25 November 2016

Arrangements for Handling Heritage Applications Direction 2015 & T&CP (Development Management Procedure) (England) Order 2015

**PROPOSED KINGSGATE LEISURE AND RETAIL DEVELOPMENT, 20-22 CROSS CHURCH STREET, HUDDERSFIELD, HD1 2TP
Application No 2016/62/92029/W**

PROPOSED SECTION A-A, THRU NEW LEISURE MALL

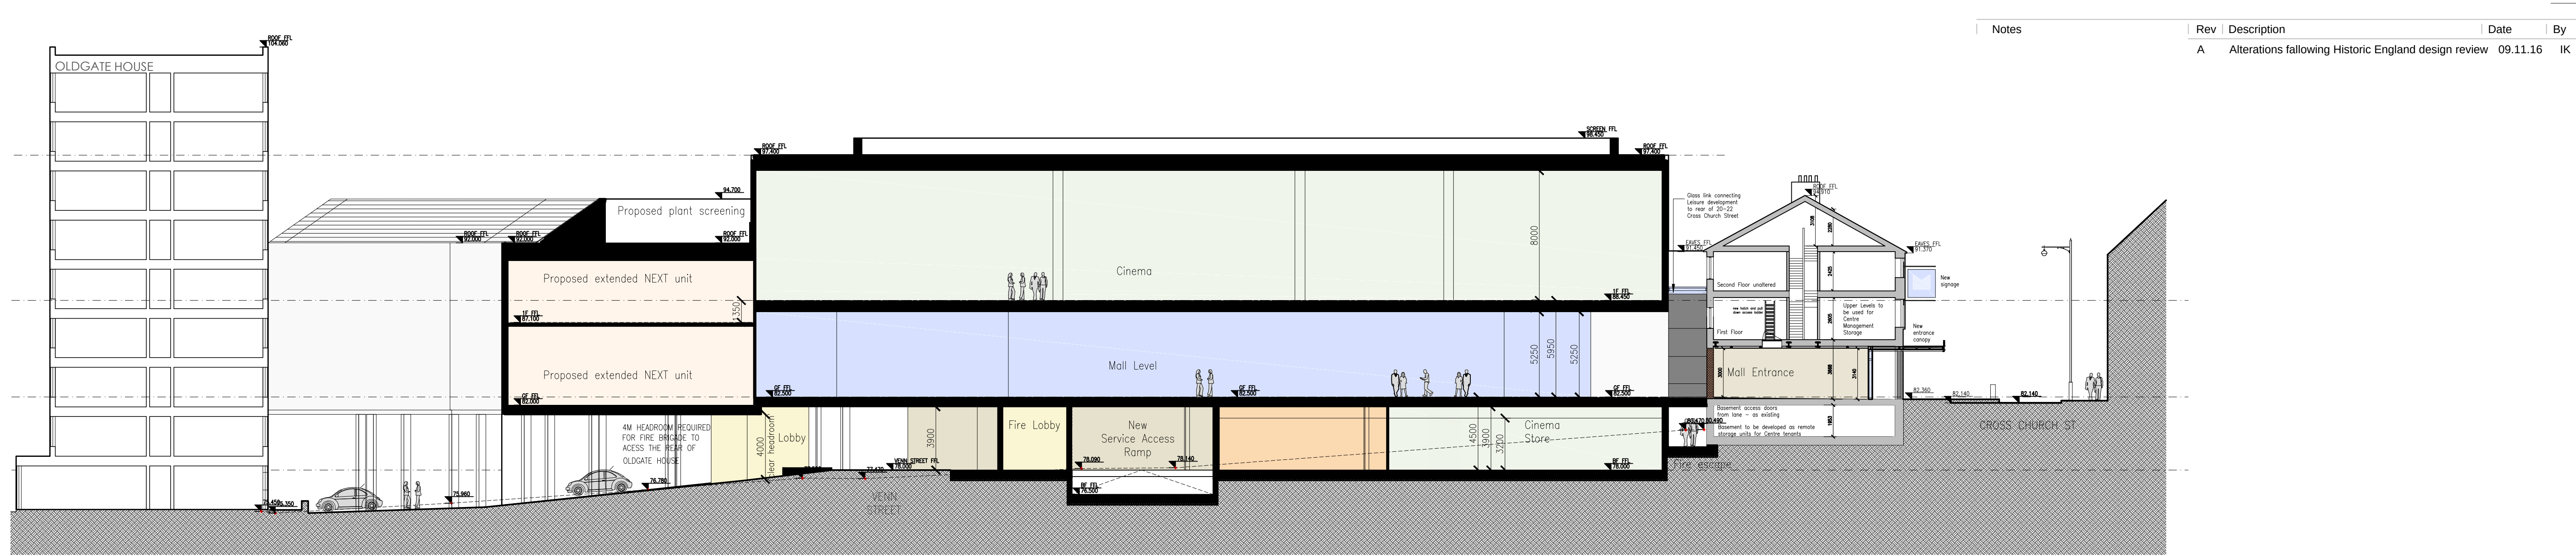
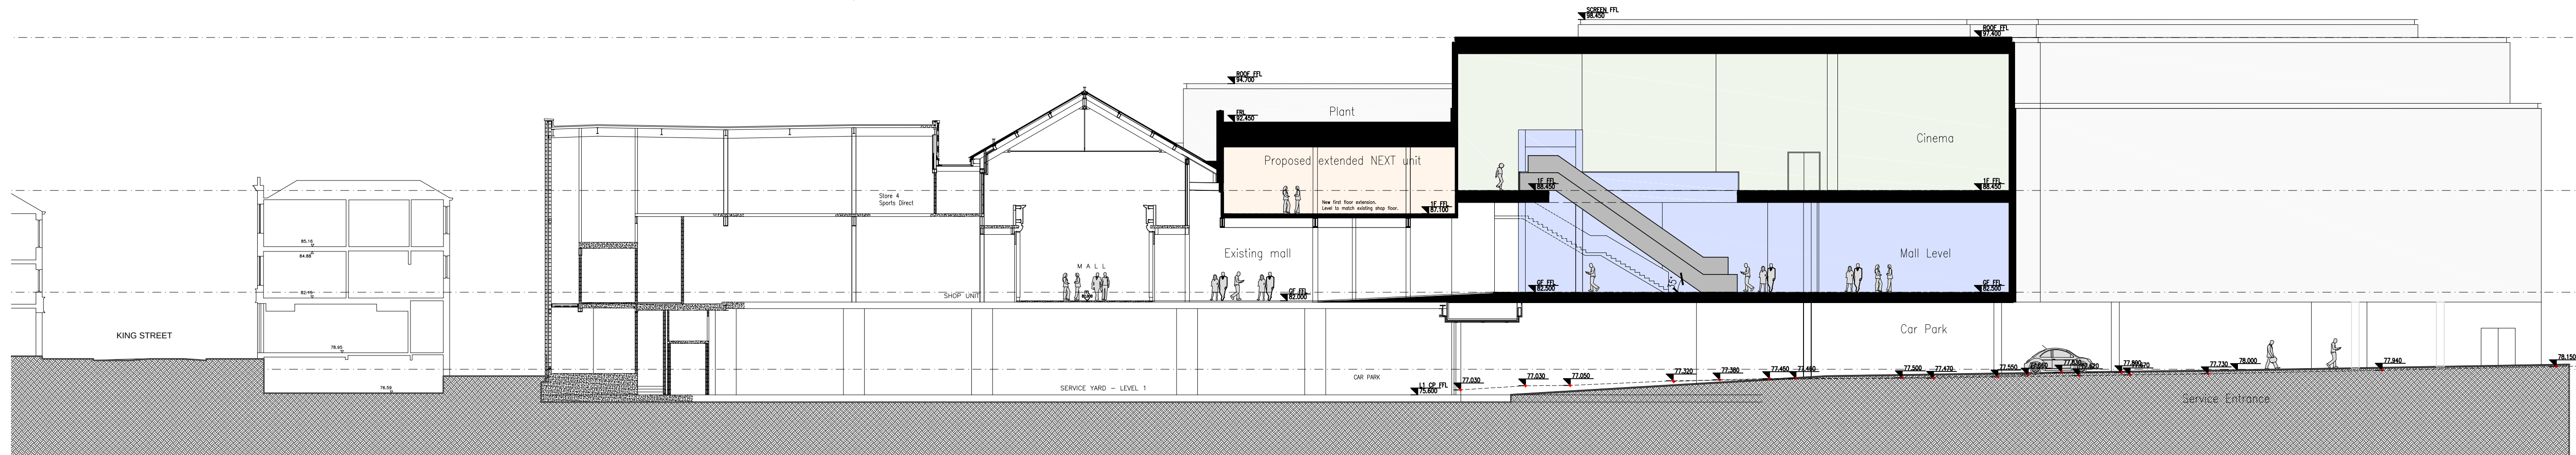
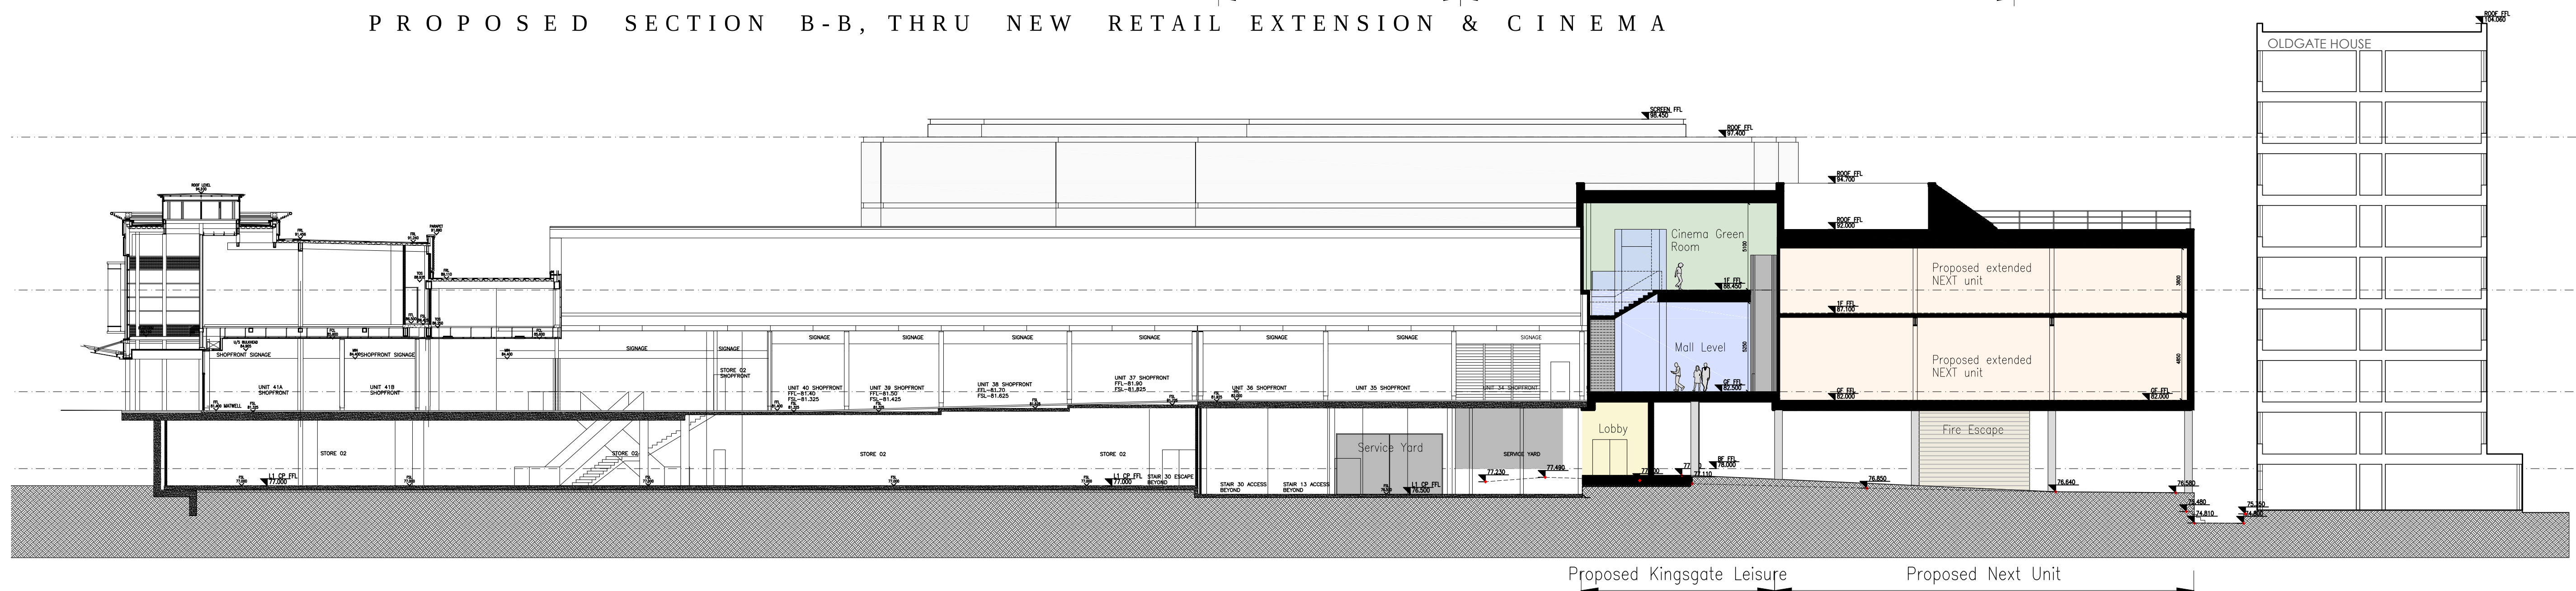
Historic England welcomes, in principle, the extension to the Kingsgate Shopping Centre. We also welcome the revised scheme which now incorporates 20-22 Cross Church Street into the proposed development and in particular we note the reduction in height of the proposed retail extension. With regard to the latter, we consider the extension will still cause some harm to the setting of St Peter's Church and also the conservation area.

However, we acknowledge the visual impact assessment which demonstrates the reduced impact of the retail extension on the character and appearance of the conservation area and the setting of the adjacent listed buildings. We consider the scheme should seek to make a clear and positive contribution to the local character and reinforce the distinctive nineteenth century urban grain of Huddersfield Town Centre. We consider it is imperative that careful thought is given to the palette of materials chosen for the retail extension and how through the use of the right materials, the harm caused by the extension can be further mitigated.

Content	PROPOSED CANOPY		
Client	WD KINGSGATE LTD		
Project	KINGSGATE LEISURE		
Date	MAY 2016	Drawing Scale	1:25@ A1, 1:50@A3
Paper size	A1	Drawn by	HB
Project Code	756F	Drawing No.	PL-16
		Revision	B

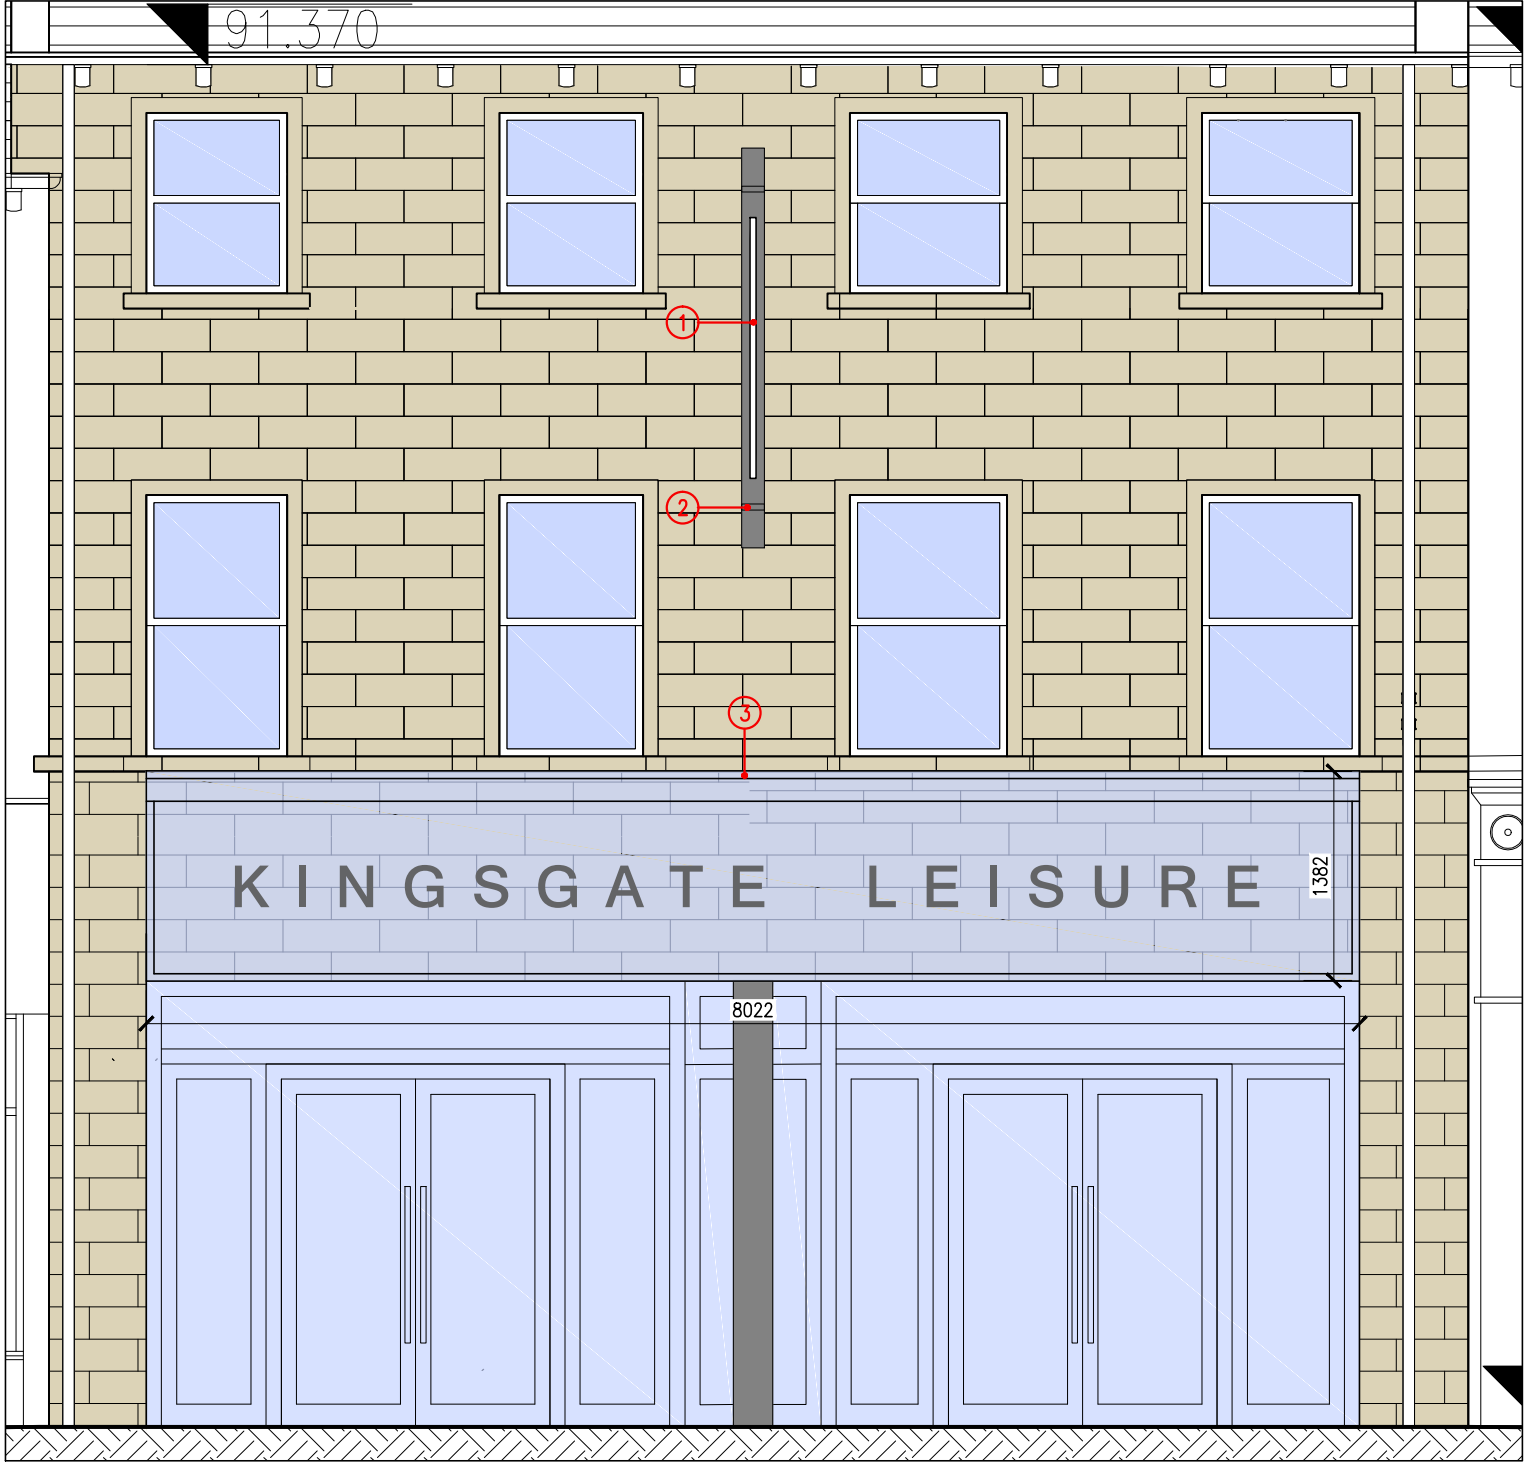
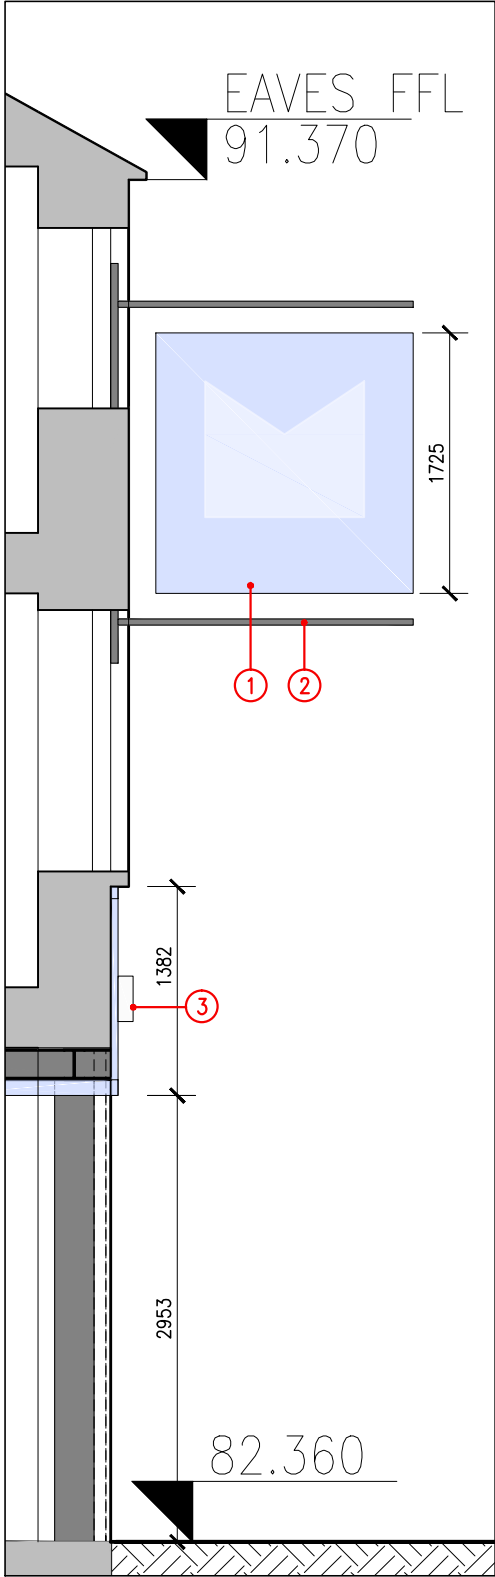
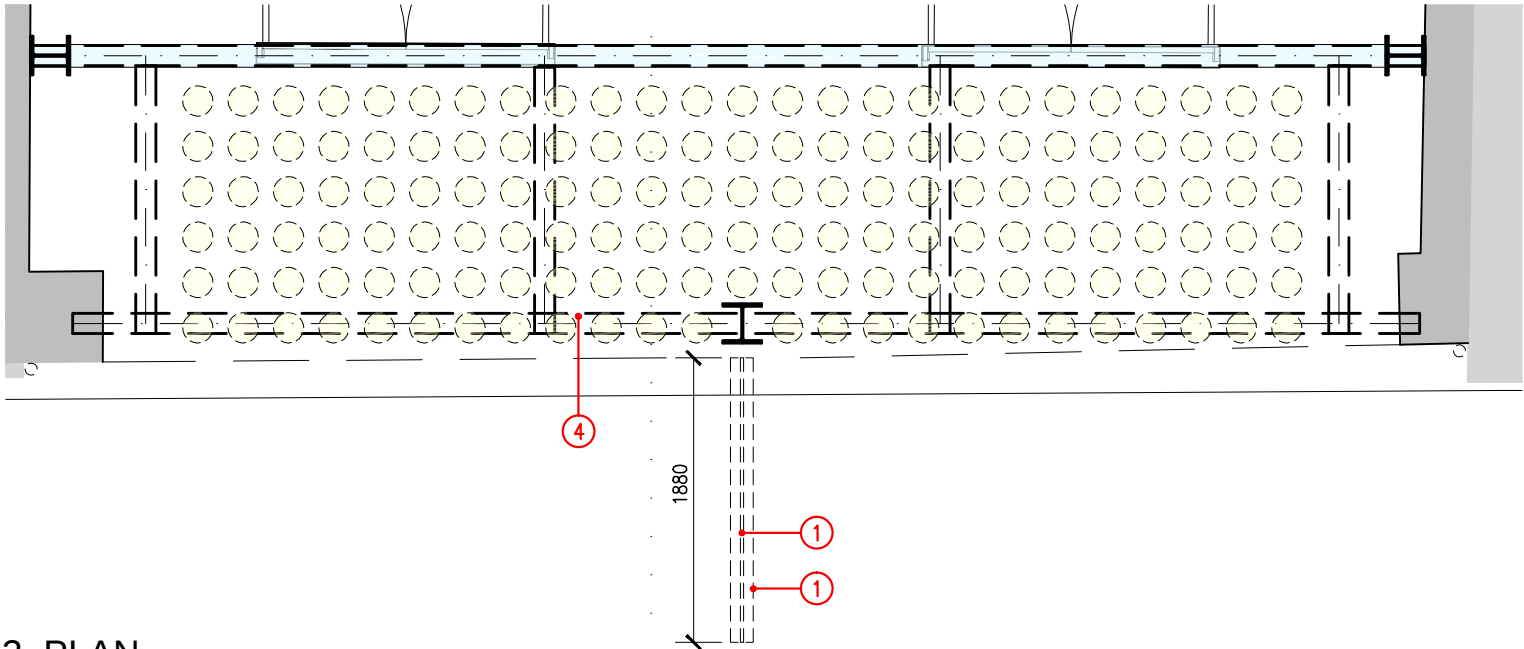
We welcome the refurbishment of the front elevations and we consider this has the potential to enhance 20-22 Cross Church Street and the wider streetscape along this important route through the conservation area. We note the latest revisions to the entrance to the cinema and we welcome the removal of the previously proposed canopy. We accept the need to clearly identify the entrance and we advise that further consideration should be given to sensitive way marking and signage as part of any forthcoming public realm proposals.
